DOC16/587110-3
DA 49/94 (MOD 8)

Rixs Creek Coal Mine - Modification 8 (DA 49/94)

Figure 3: Location of proposed stockpiling areas

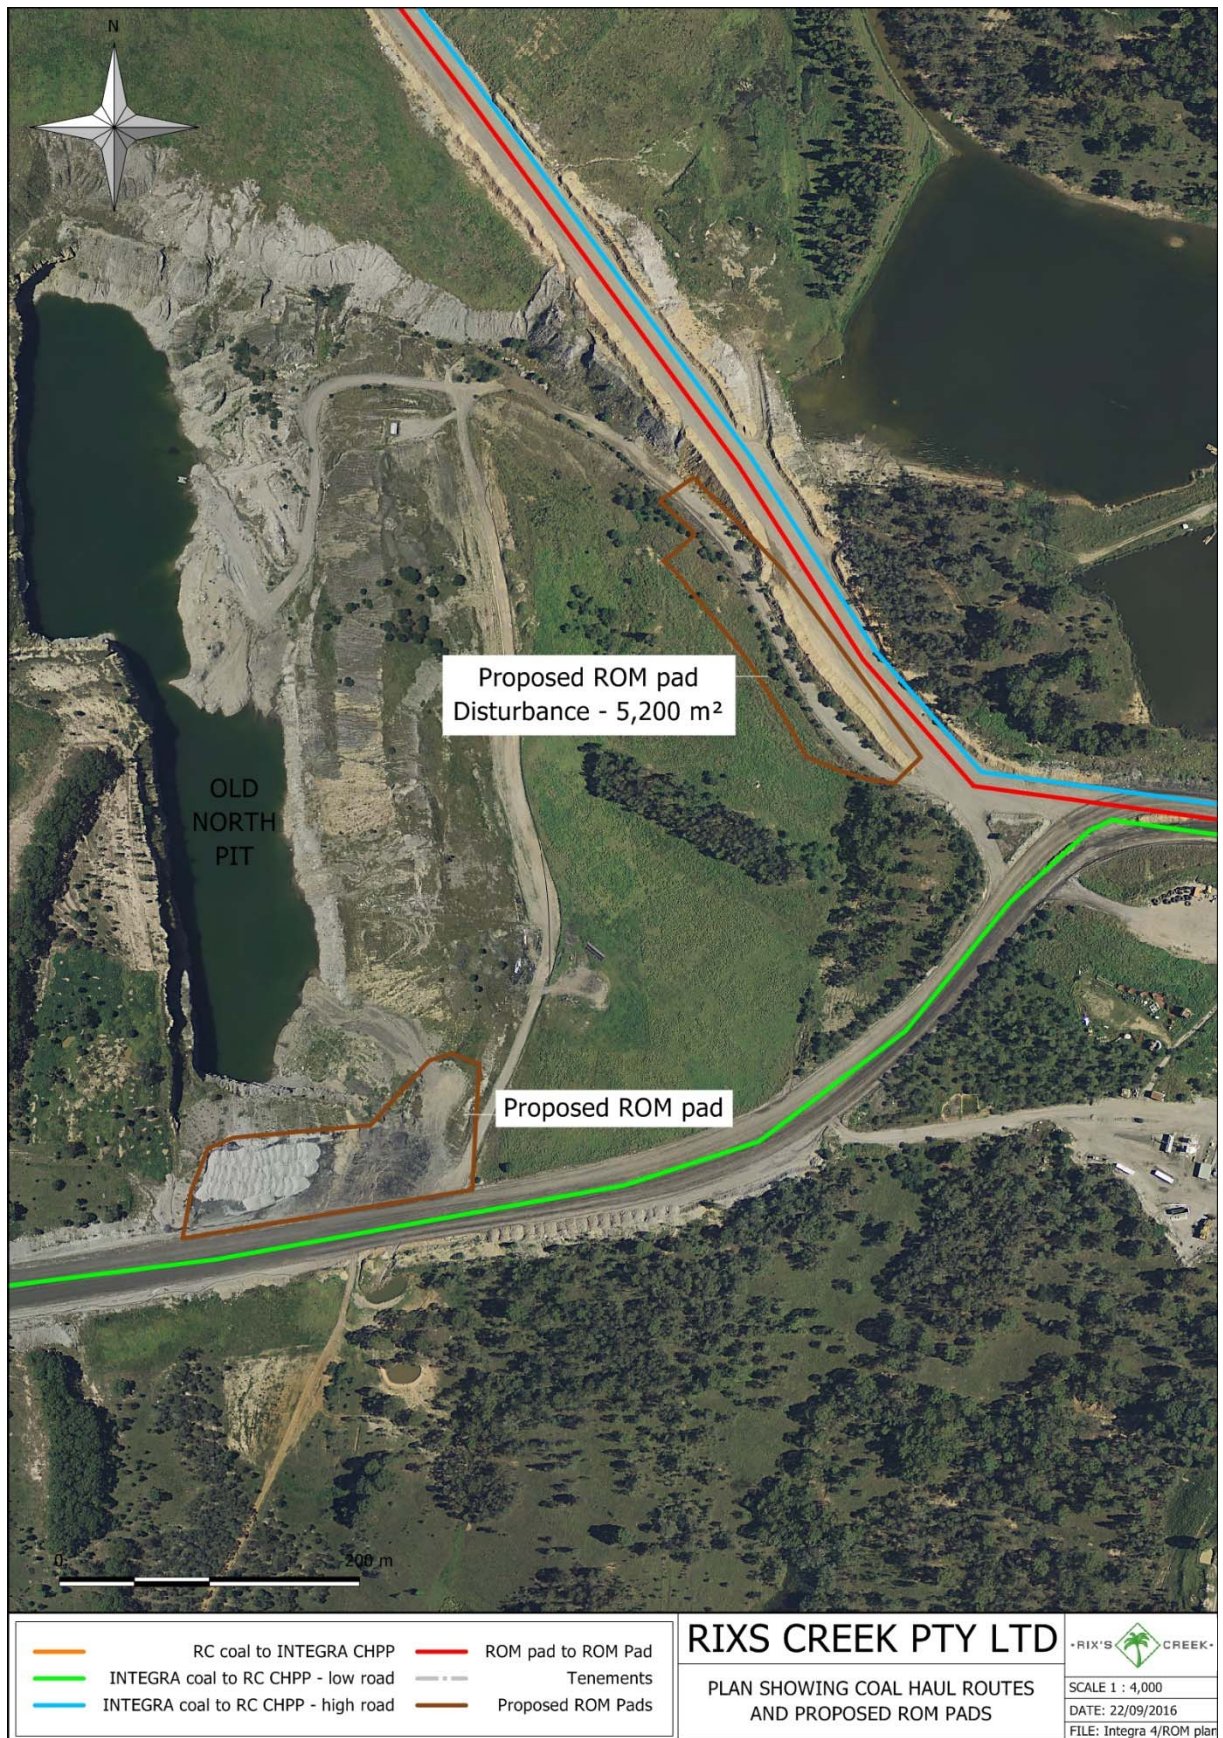
I refer to your e-mail dated 6 December 2016 seeking clarification from the Office of Environment and Heritage (OEH) in relation to a suggested change to our recommended condition of consent for the Rixs Creek Coal Mine (letter dated 28 November 2016, DOC16/587110-1). OEH acknowledges that the proponent will have operational issues with the recommended timeframe for woody revegetation of at least half of the new run-of-mine (ROM) pad area due to future likely use of those pads once the new coal handling and processing plant for Rixs Creek North is operational. OEH is therefore in agreement that woody revegetation of any of that land is not feasible in the timeframe suggested in our previous advice.

Removal of the timeframe for revegetation of the two ROM pads could therefore extend the need to revegetate these areas until the end of the current mining consent (in 21 years' time). While OEH agrees with the need to keep these new ROM pads available for use during this time, the expected level and nature of revegetation may have changed by then. Therefore, OEH agrees with the removal of the timeframe in the recommended condition, as per your e-mail, but suggests that the final condition provides scope for the quality of revegetation to be at the standard required of the mine site at that time.
